Alan Varela, Director

July 30, 2024

**RE: Caliber Collision – 250 98th ST NW
Erosion and Sediment Control Plan
Engineer's Stamp Date 3/7/24 (D17E008)**

CITY OF ALBUQUERQUE PUBLIC WORKS DIVISION ENGINEERING GROUP	
Caliber Collision EROSION CONTROL DETAILS	
DESIGN REVIEW COMMITTEE	CITY ENGINEER APPROVAL
LAST DESIGN UPDATE	MO./DAY/YR.
	MO./DAY/YR.
	MO./DAY/YR.
	MO./DAY/YR.
SHEET # 25 of 25

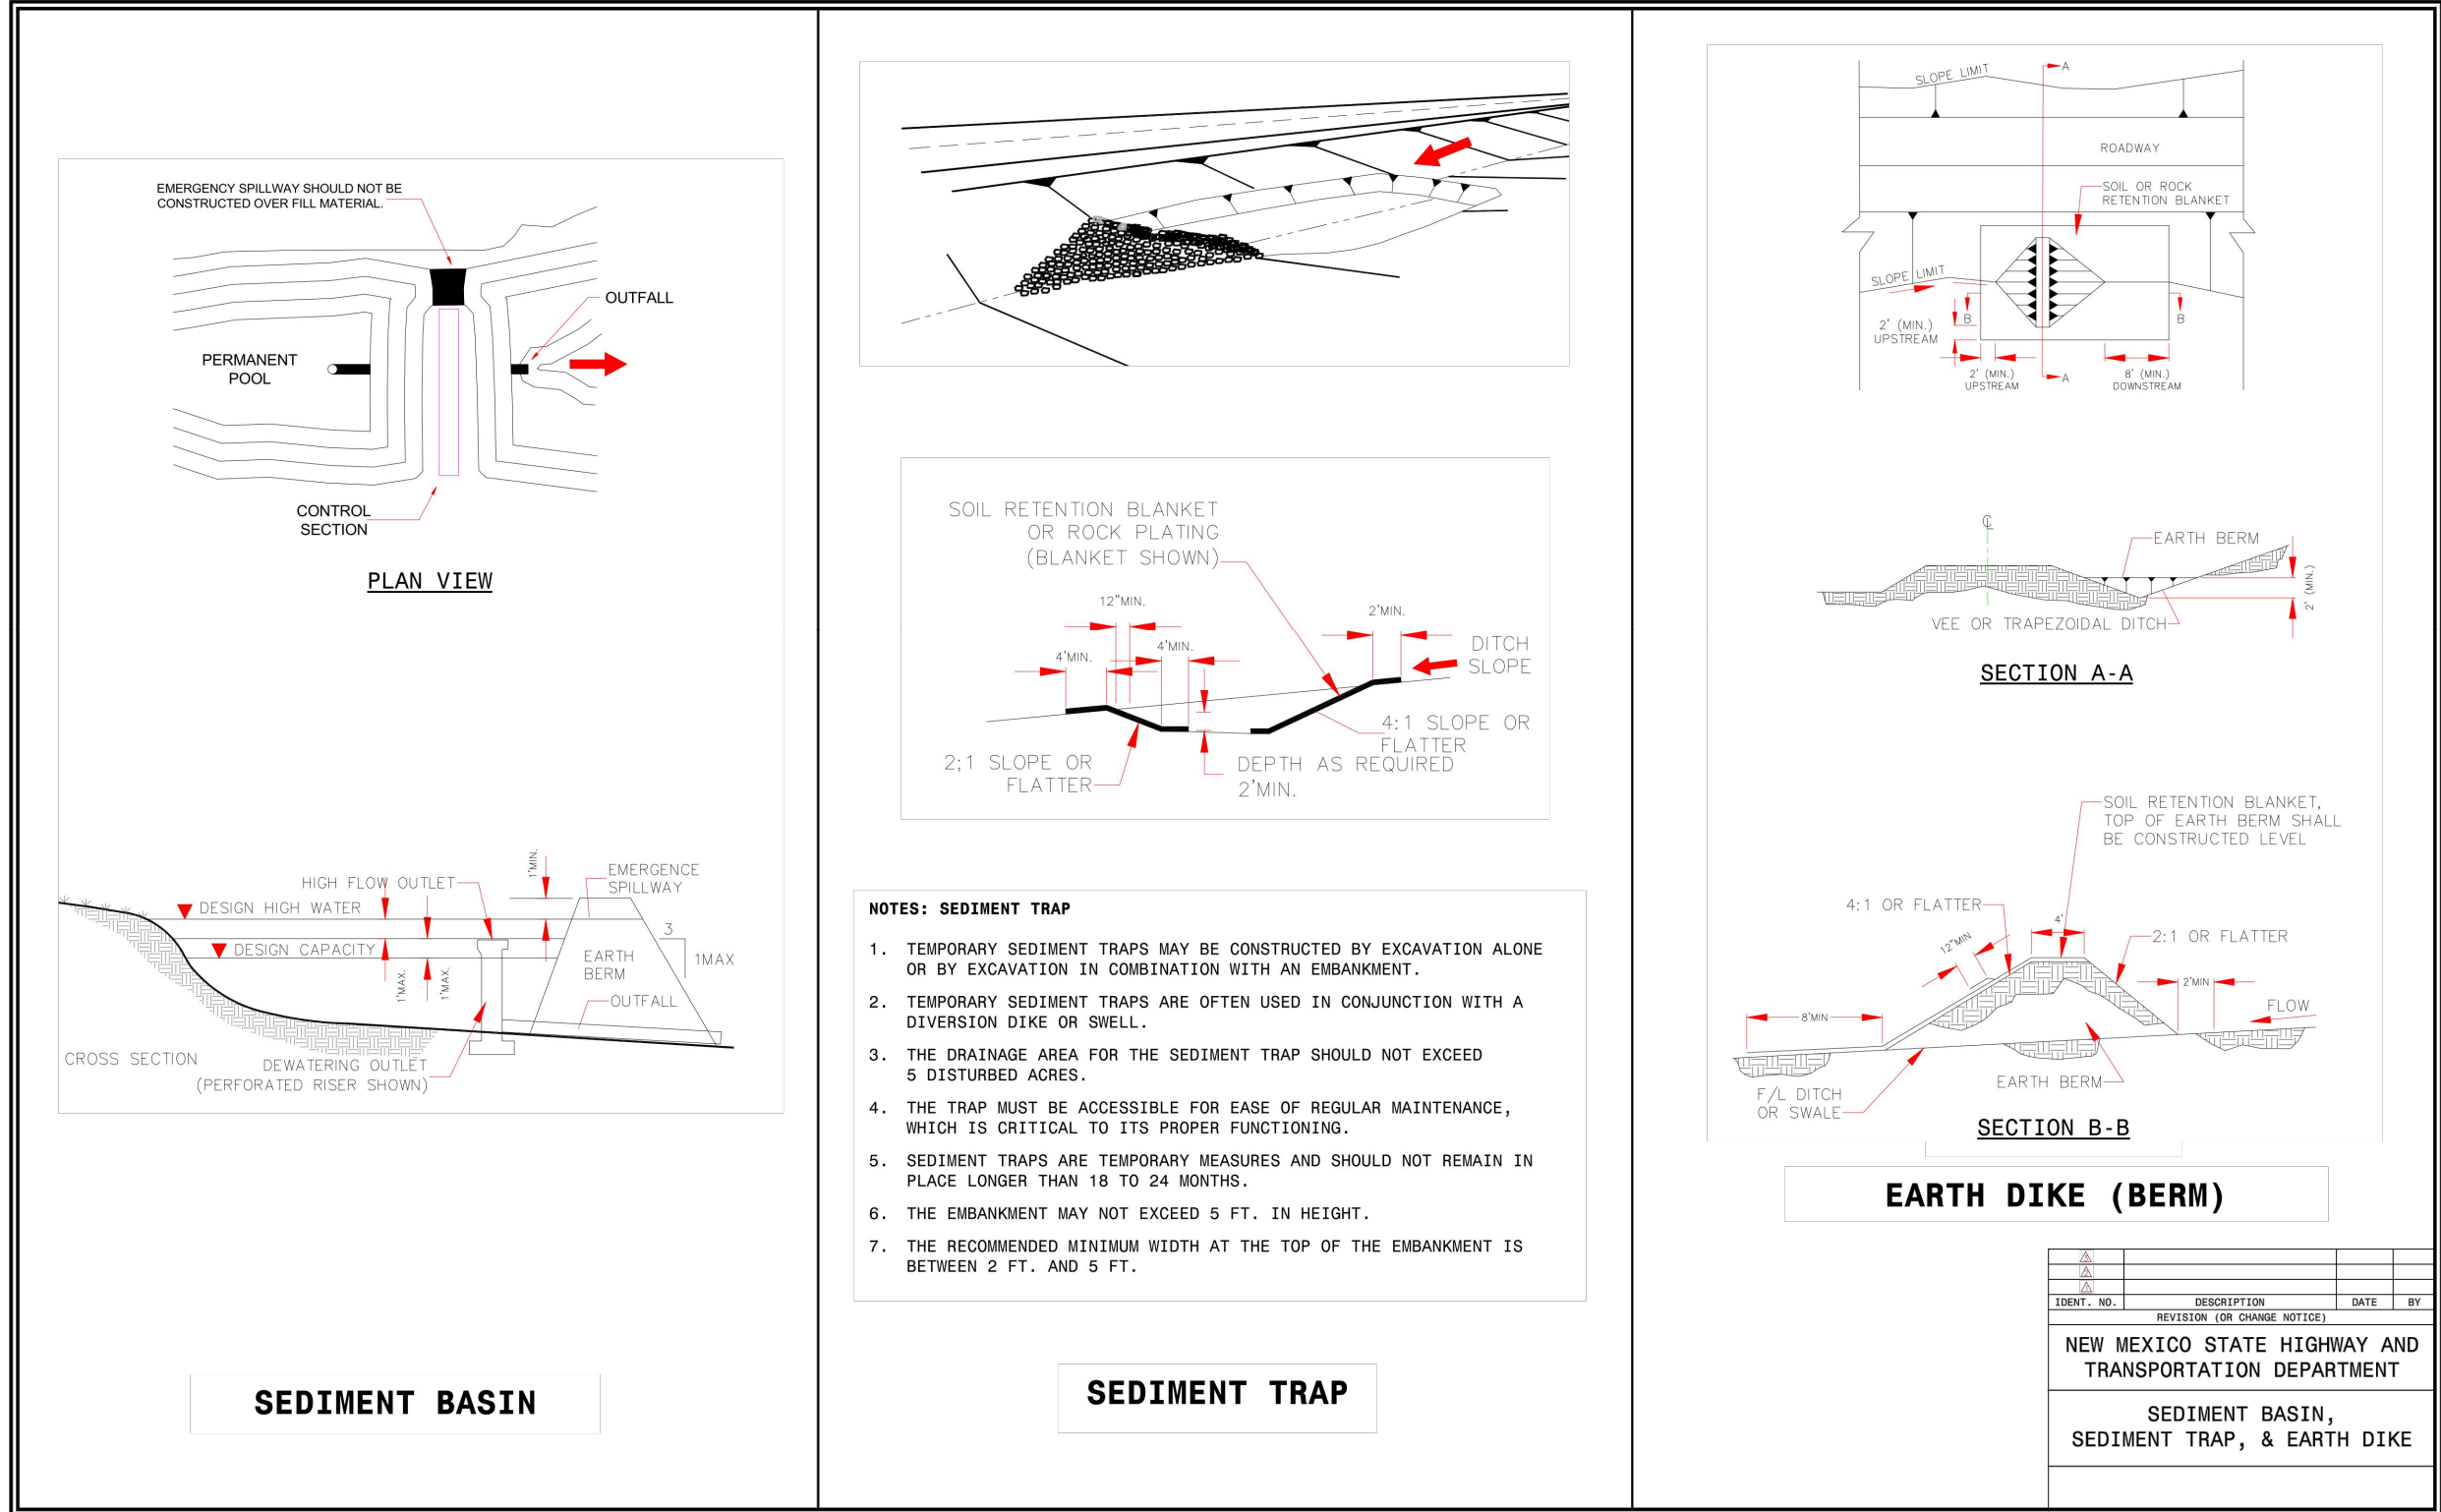
7. The Erosion and Sediment Control ESC Details are missing the construction, inspection, and maintenance specifications, as required by the city's ESC Plan Checklist and by CGP 9.6.1.c.i. *Erosion Control details provided.*
